AFRA CONSTRUCTION, LLC
2501 YALE BLVD. SE, SUITE 102
ALBUQUERQUE, NM 87106
PHONE: 505-242-1745
FAX: 505-242-1737

November 14, 2016

Re: Project #1001695 Signal Allergy Clinic – EPC Comment Responses

SP-1
11/14/2016

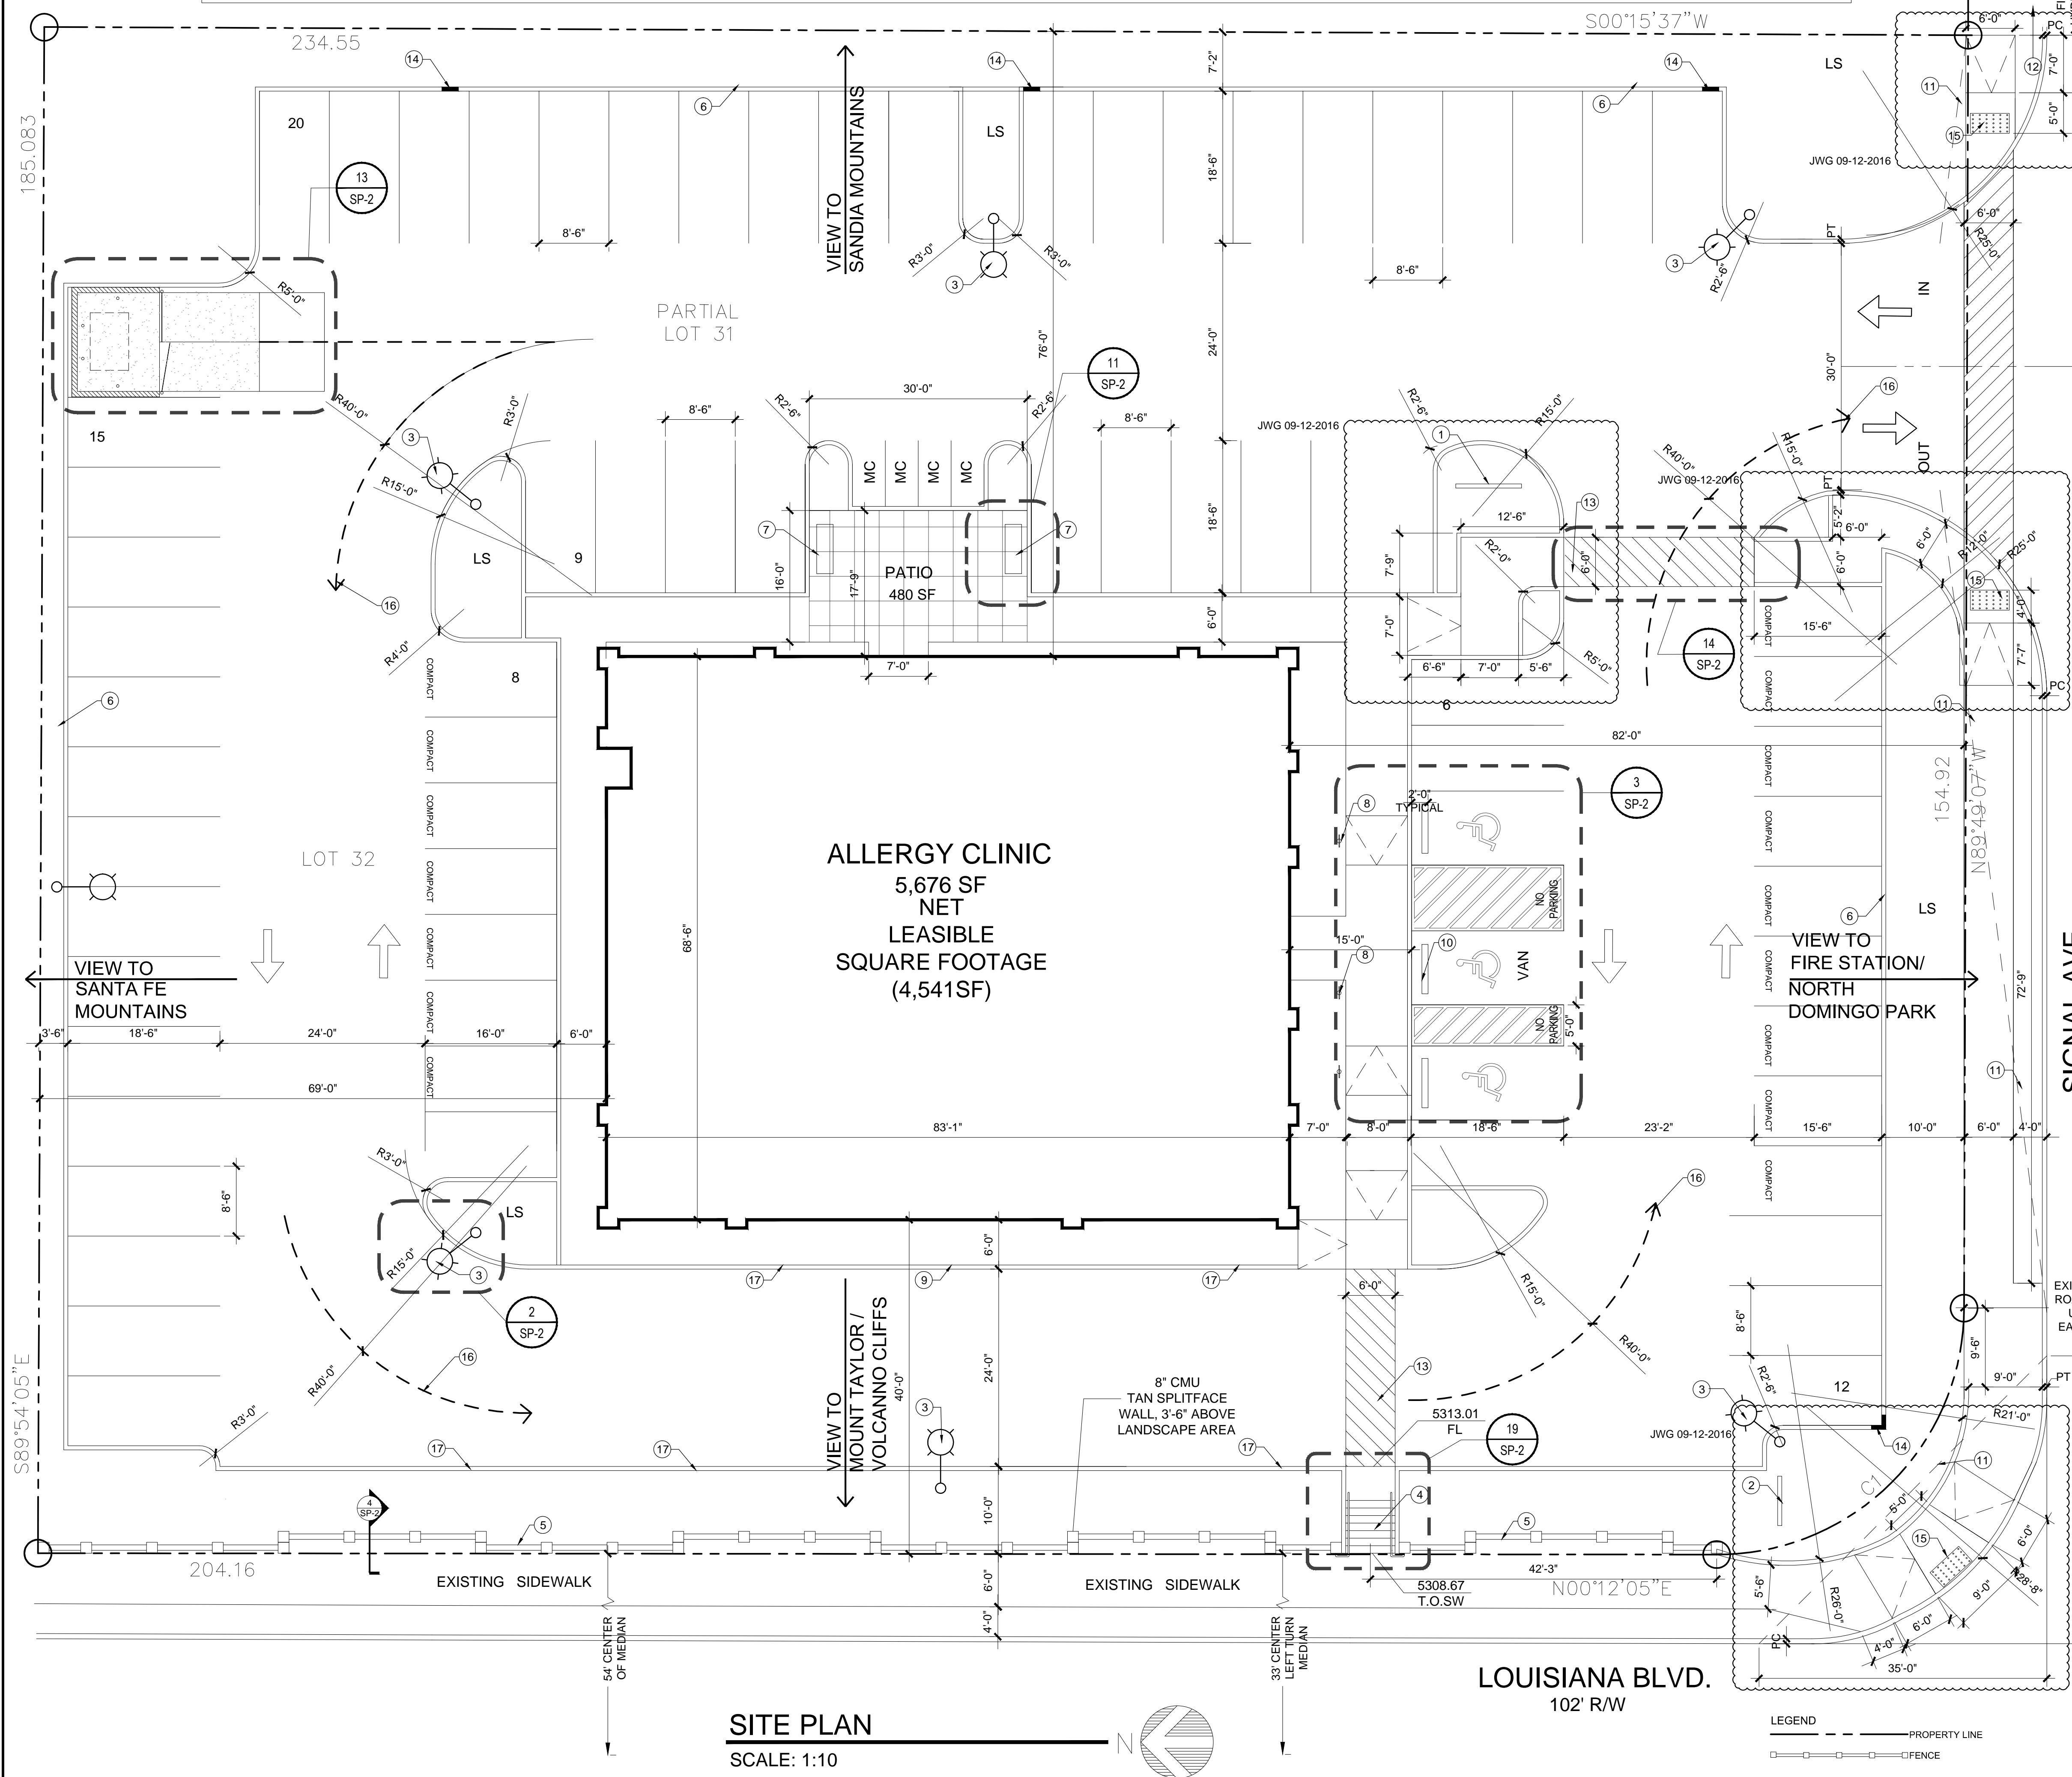
1. Complied.
2. Will Comply.
3. Will Comply. (In Process)
4. ***Pedestrian Access and Circulation:***
 - A. ***A 15 foot pedestrian sidewalk shall be provided along the entire entry façade (LCSDP 3R-4)***

- C. ***Pedestrian connections shall be at least 6 feet wide [14-16-3-1(H), Off-Street Parking Regulations]***
 - The west most pedestrian connection has been revised from 5'-6" to 6'-0". The remaining pedestrian walkways are currently 6'-0", see sheet SP-1.

- A. The plaza/patio area shall be revised to have a minimum depth of at least 30 feet on one of its sides. (LCSDP 8R-3)**
- East side of patio measures 30'-0", Refer to sheet SP-1.
- B. The plaza/patio area shall be dimensioned.**
- Dimensions added, refer to sheet SP-1.

- A. The minimum required length of parking space is 18 feet, including overhang.**
 - All parking spaces measure 18'-6", refer to Sheet SP-1 for dimensions.

- B. Identify the right of way width, medians, curb cuts, and street widths on Louisiana Blvd. and Signal Ave.**
 - Dimensions for the right of way and curb cuts have been added, refer to sheet SP-1 for dimensions.

- D. Please detail and dimension all proposed sidewalk, ADA ramps, and curb cuts to proposed development. Dimension distance from intersection of Louisiana Blvd. and Signal Ave. to proposed new curb cut entrance/exit.**

- Labeling has been included, see sheet SP-1 for compact parking spots on North side of the building.
- H. Per the DPM, a 6 ft. wide ADA pedestrian pathway is required from the public sidewalk to the building entrances. Please clearly show this pathway and provide details.**

- I. Please provide a sight distance exhibit (see the Development Process Manual, Chapter 23, Section 3, Part D.5 Intersection Sight Distance)**
 - Provided on the bottom right hand corner of sheet SP-1.

- J. Please add the following note to the clear sight triangle: "Landscaping and signage will not interfere with clear sight requirements. Therefore, signs, walls, trees, and shrubbery between 3 and 8 feet tall (as measured from gutter pan) will not be acceptable in this area.**

- The entry sidewalk was increased from 10'-5" to 15'-0" along the entry façade, see sheet SP-1.
 - B. ***A pedestrian connection to the site adjacent north shall be provided (LCSDP 3R-5)***

- Dimensions for sidewalks, ramps, and curb cuts have been added as well as the distance from Louisiana Blvd to the new curb cut, refer to sheet SP-1 for dimensions.

- Provided on the bottom right hand corner of sheet SP-1 below clear site triangle detail.

6 LANDSCAPE CURB DETAIL  
SP-2 SCALE: 1/2"=1'-0"

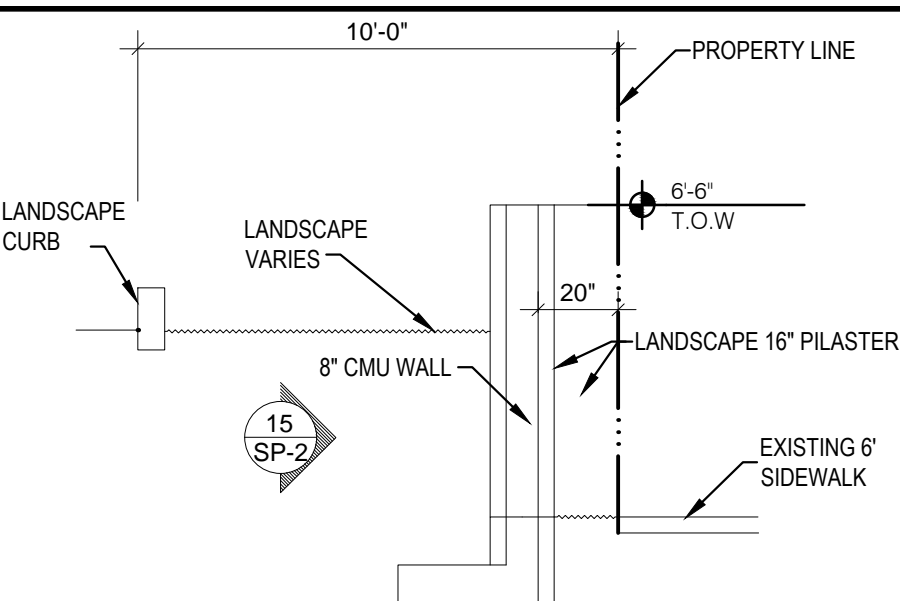
- E. Landscape areas shall be depressed below grade.**
- All Landscape areas are 8" below landscape curb, see sheet Sp-2, Detail 6.

3 ACCESSIBLE PARKING SPACES  
SP-2 SCALE: 3/16"=1'-0"

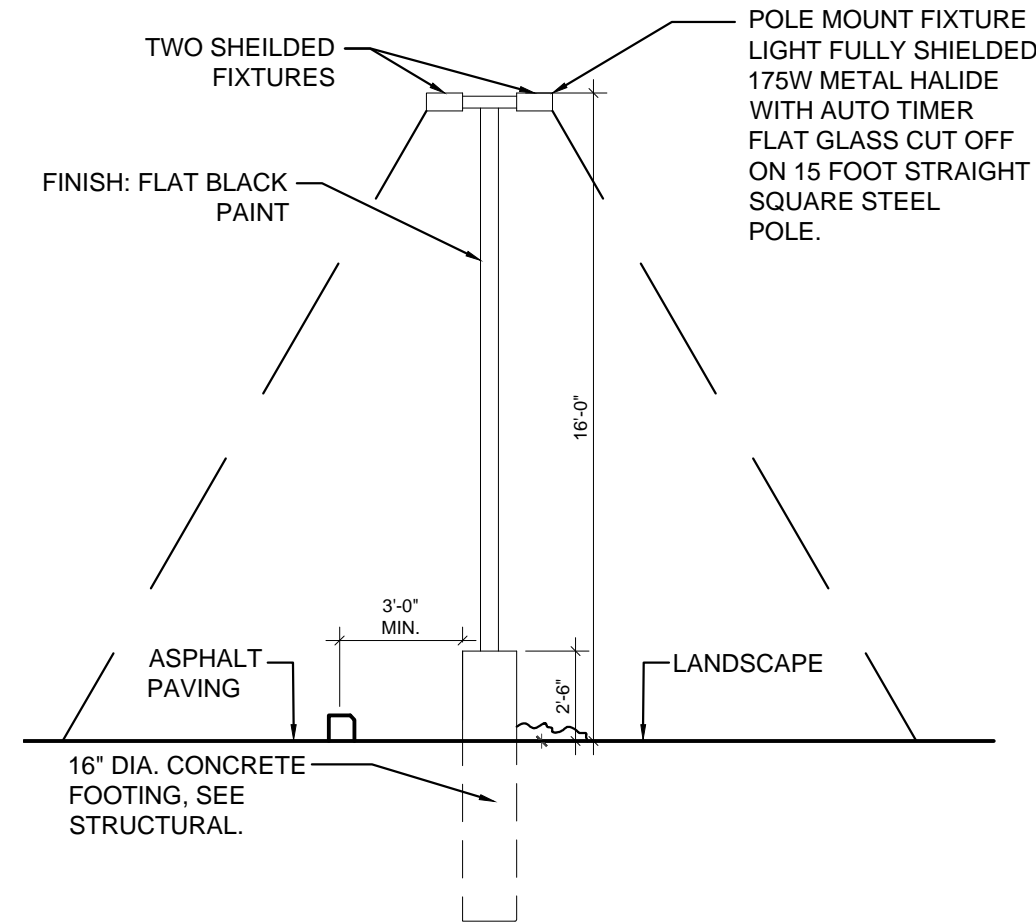
- C. At ADA spaces, vehicles cannot overhand ADA ramps. Please provide wheel stops in the 18.5 feet ADA parking spaces.**
 - Wheel stops have been provided, refer to sheet SP-1 and SP-2, Detail 3.

- E. The ADA access aisle shall have the words "NO PARKING" in capital letters, each of which shall be at least one foot high and at least two inches wide, places at the rear of the parking space so as to be close to where an adjacent vehicle's rear tire would be place (66-1-4.1.B NMSA 1978)**

- Labeling has been included, refer to sheet SP-1 and sheet SP-2, Detail 3 for ADA labeling and label dimensions.
- F. At ADA spaces, vehicles cannot overhand ADA ramps. Please provide wheel stops in the 18.5 feet ADA parking spaces**

2 SHIELDED LIGHT POLE  
SP-2 SCALE: 3/16"=1'-0"

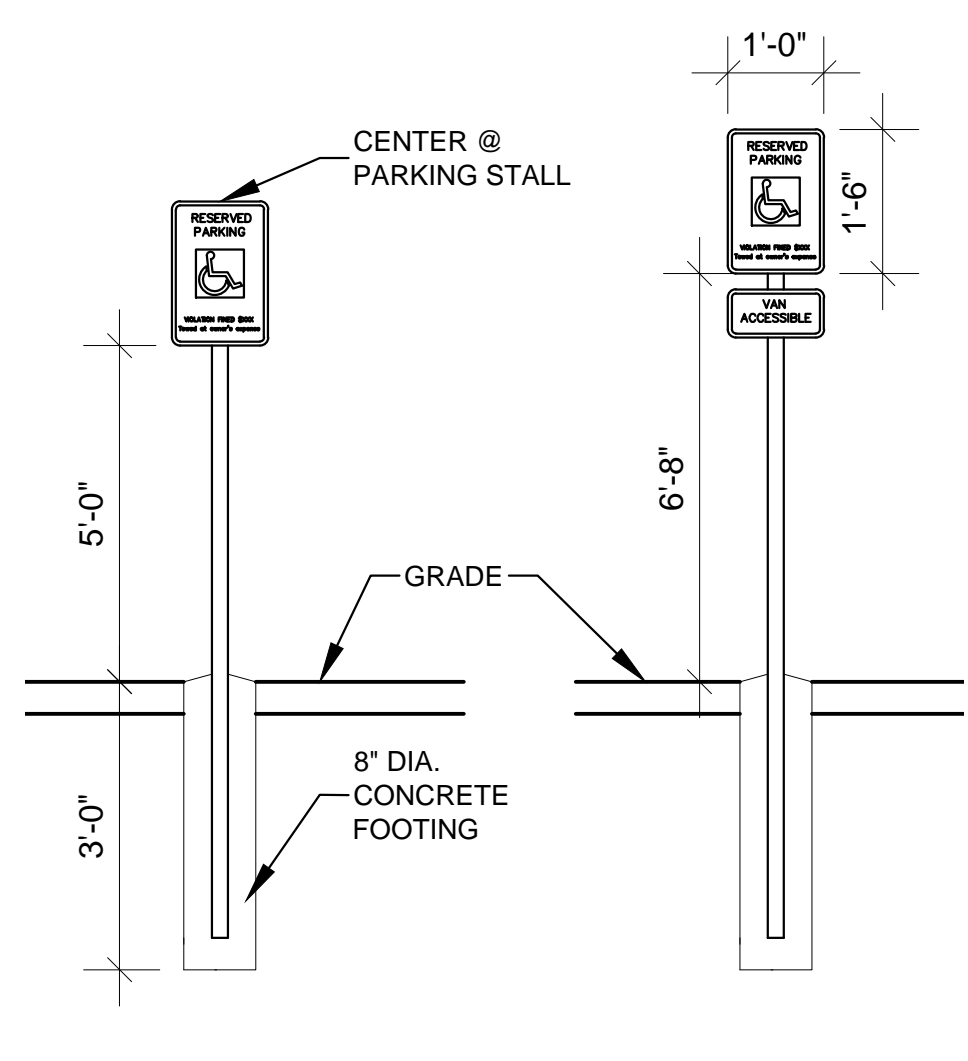
- A. A note shall be added to the site development plan to state that all outdoor light fixtures will have light and motion sensors and/or automatic timers (LCSDP 14R-4).**
- A note has been added to sheet SP-2, Detail 2 calling out automatic timers.

10 MONUMENT SIGN ELEVATION  
SP-2 SCALE: 1/4"=1'-0"

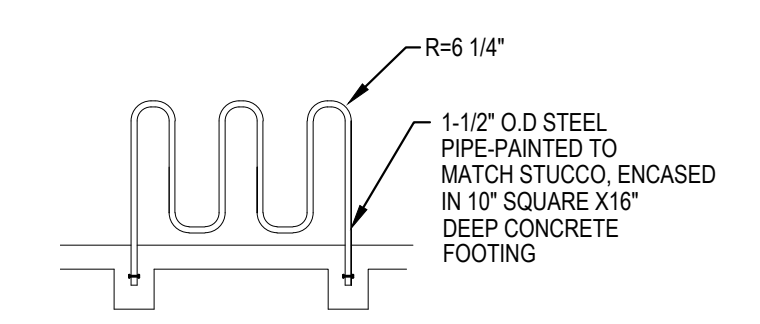
- A. Design details and color(s) of the monument sign shall be specified.**
 - Design details added to monument sign, refer to sheet SP-2, Detail 10.
- B. Clarify whether or not ground-mounted lighting is proposed for the monument signs.**
 - No ground mounted lighting will be used on monument sign, it will be backlit.
- C. Specify the material(s) of the building mounted sign and ensure that it is not plastic panel sign.**
 - The sign will consist of individual letters that are back lighted, not plastic panel sign.
- D. Add a note to specify that all signage must comply with LCSDP requirements.**
 - Note added to signage on sheet SP-2, Detail 10.

14 PEDESTRIAN PATHWAY  
SP-2 SCALE: 1/2"=1'-0"  
COMPLY WITH 14-16-3-1-(H)

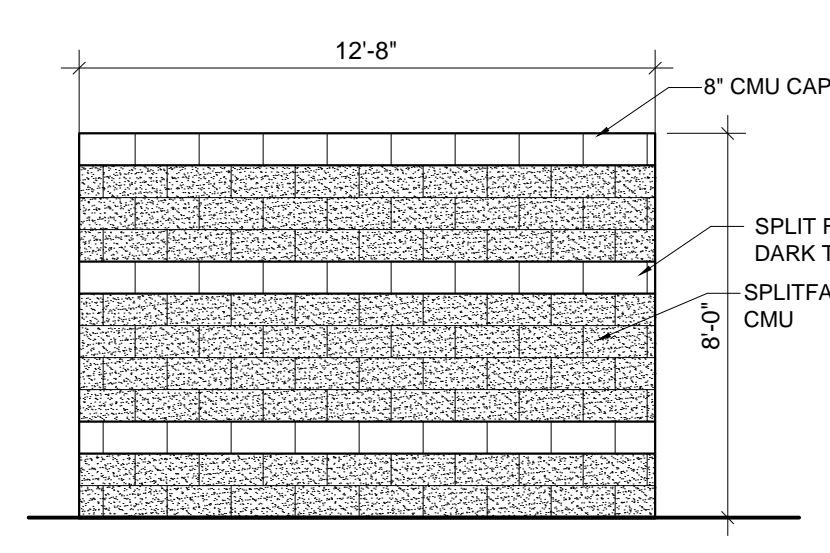
- D. ***The pedestrian pathway shall show textured, colored concrete as required [14-16-3-1(H), Off-Street Parking Regulations]***
 - A note indicating that walkway should have color and texture are included SP-1, keyed note 13 and on SP-2, Detail 14.

17 TYPICAL SIDE ELEVATION AT TRASH ENCLOSURE  
SP-2 SCALE: 1/4"=1'-0"

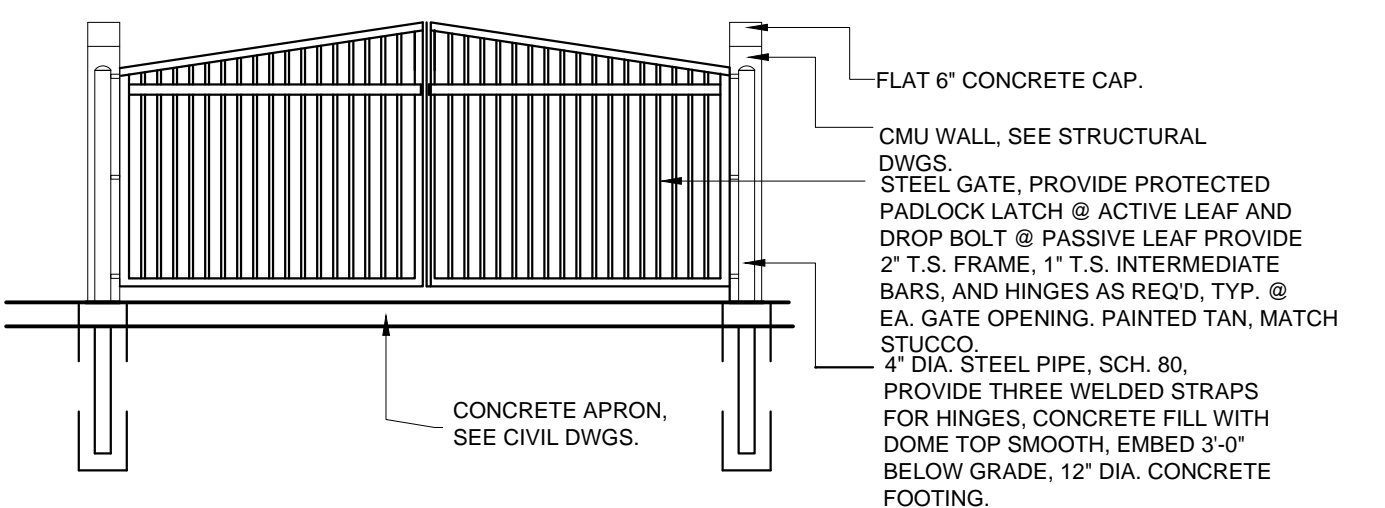
5. ***Walls:***
 - A. ***The tan block shall be either split face or stucco over concrete masonry unit, but no unfinished tan block (LCSDP 10R-2)***
 - Unfinished block has been changed to split face of a different color than adjacent block, see sheet SP-2, Detail 15 & 17.
